**ADC Planning Consultation
Response from the Conservation Officer**

Application Number	AW/91/13/
Address	22 The Drive Aldwick PO21 4DU
Description	Front boundary wall and gates
Case Officer	Mr S Davies

PLAN NO 630|3

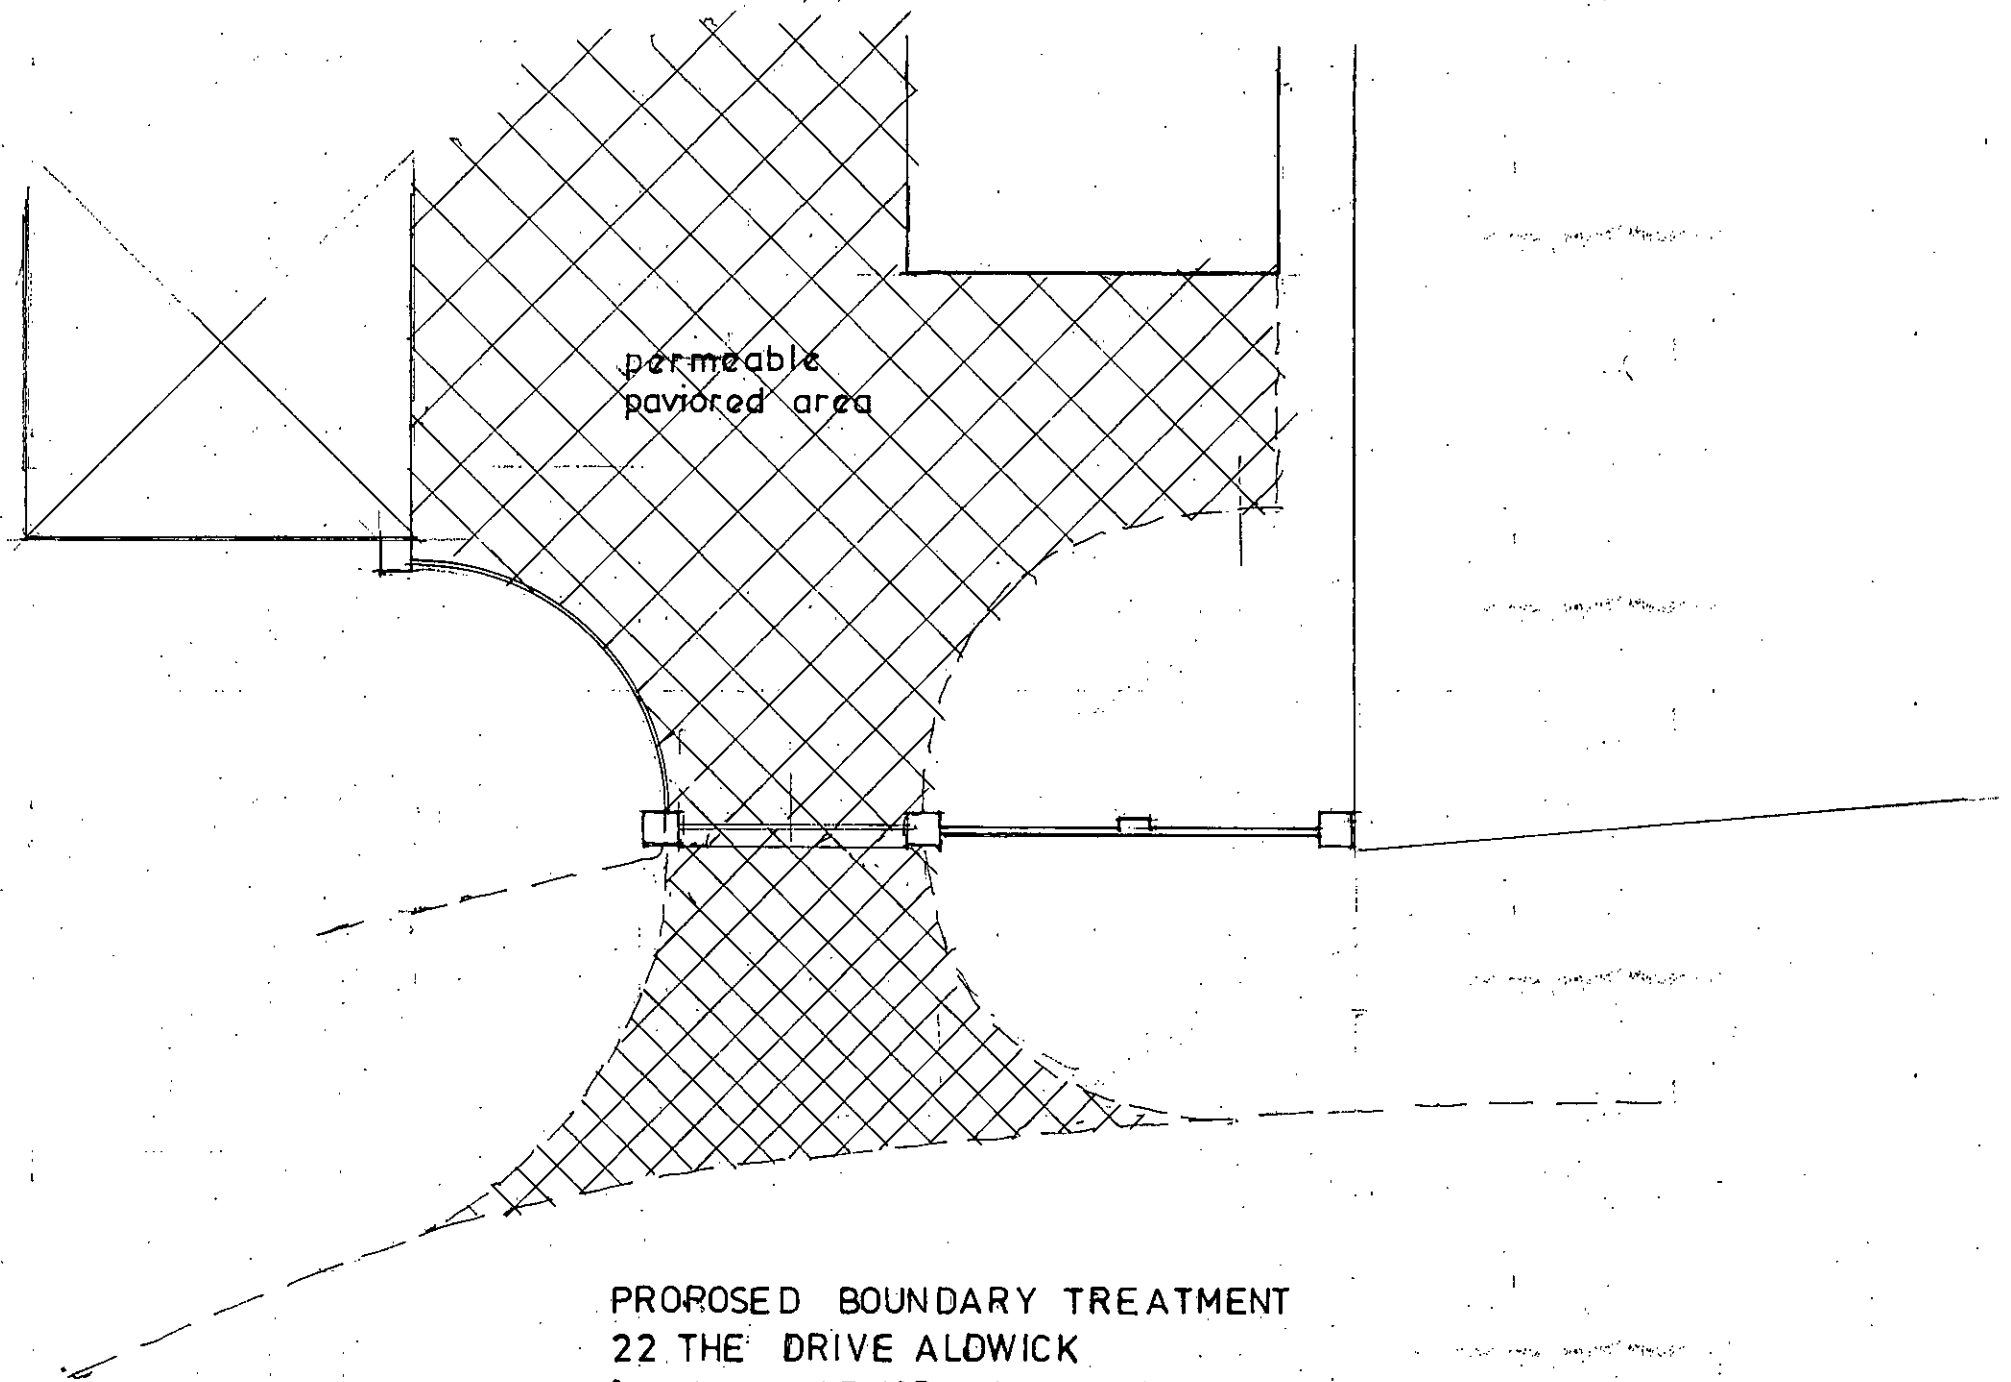
It is the location of these trees that has had a direct impact on the layout of the proposal; the line of the wall is curved to avoid them. This, then, creates an unusually shaped wall on the roadscape which would appear to be somewhat incongruous.

In addition, the wall has the effect of enclosing the private driveway which provides access the property and its neighbours. This is in conflict with the established character.

I would question the location of the wall in respect of its direct impact upon the trees. I assume that the Arboricultural Officer has been consulted and will provide comments.

I note the fact that the plans identify new paving material, but assume that this does not form part of the proposal, since there is no additional information associated with it.
